**Consultation Response from KC,
Highways Development Management****2022/92368 Land off, Liley Lane, Grange Moor, Huddersfield, WF4 4EN****Change of use of building and land from equestrian to dog care centre****Date Responded: 02/08/22****Responding Officer: J Turner****Responding Ref: K16-2/10**

22-058 - SK01
Happy Hounds HQ,
Liley Lane,
Grange Moor,
WF4 4EN.

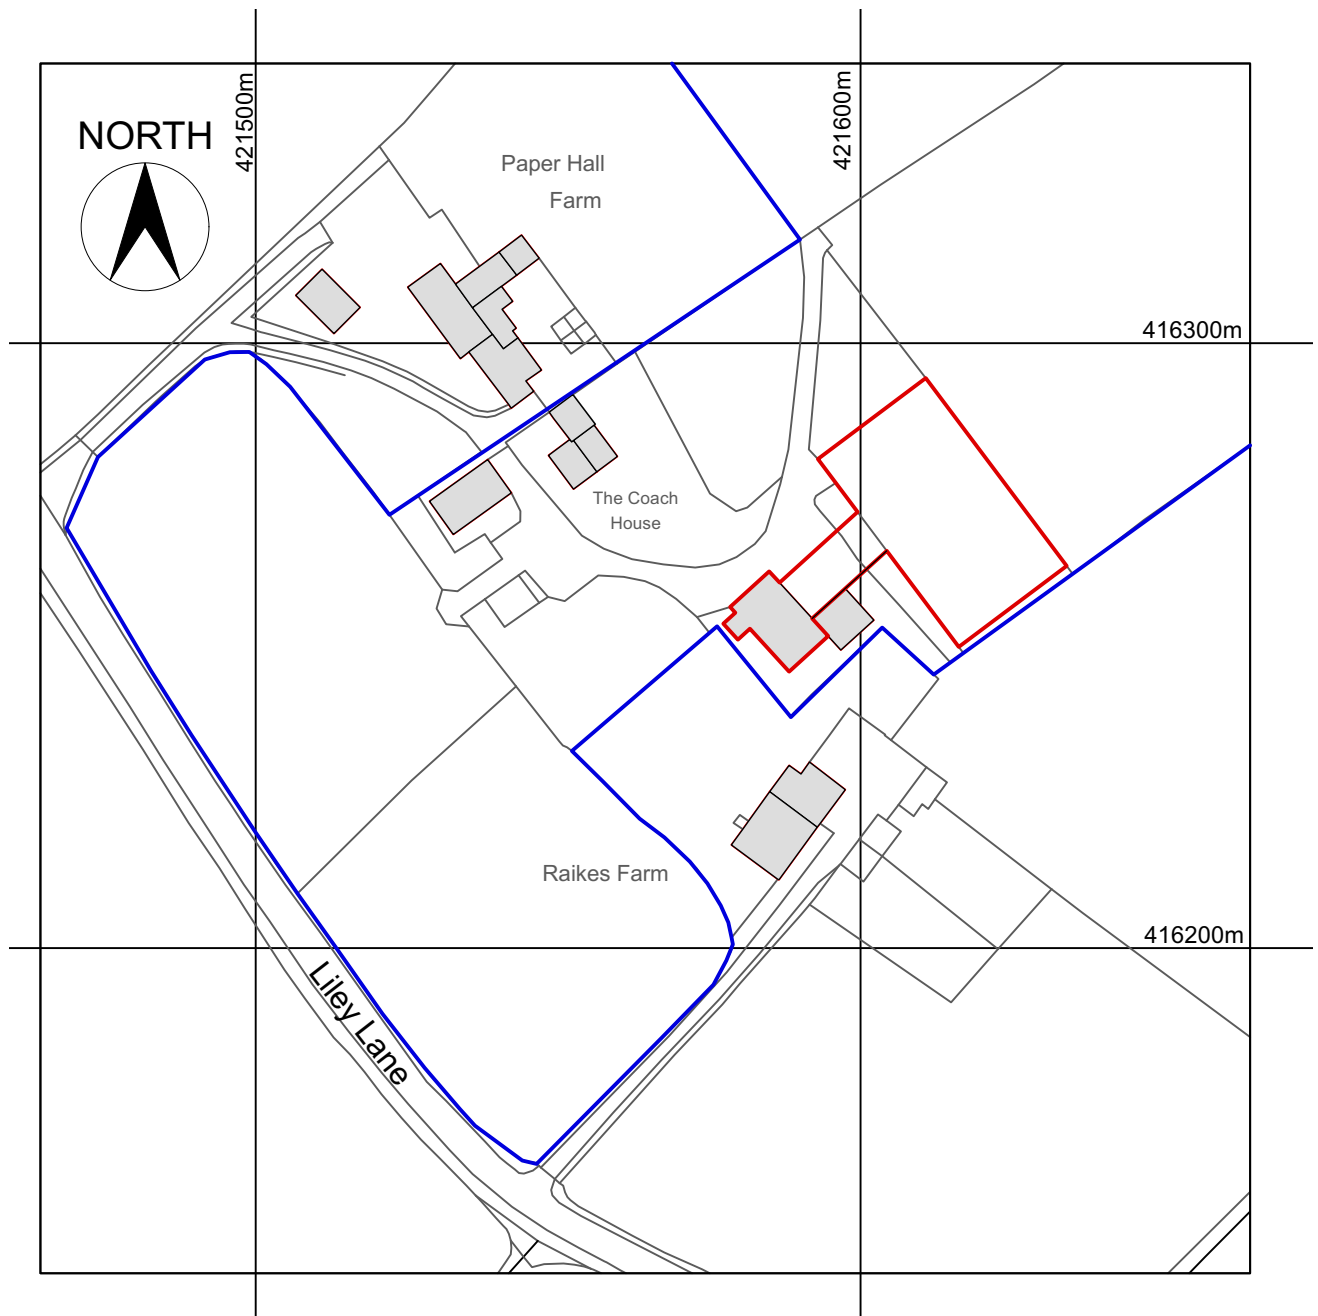
- Details of the proposed business operation including maximum customer numbers and how they are anticipated to drop off their dogs, how long the dogs will be at the premises (i.e. could there be crossover between customers?) etc.
- How the site will be accessed – the red line boundary does not run to the public highway.
- Visibility splays from the access onto the public highway demonstrated on a plan. These should be commensurate with the actual driven speeds on Liley Lane.
- Parking spaces demonstrated on a plan, along with evidence that vehicles can enter and exit the site in a forward gear.
- The access width dimensioned on a plan to ensure drivers are able to safely pass.
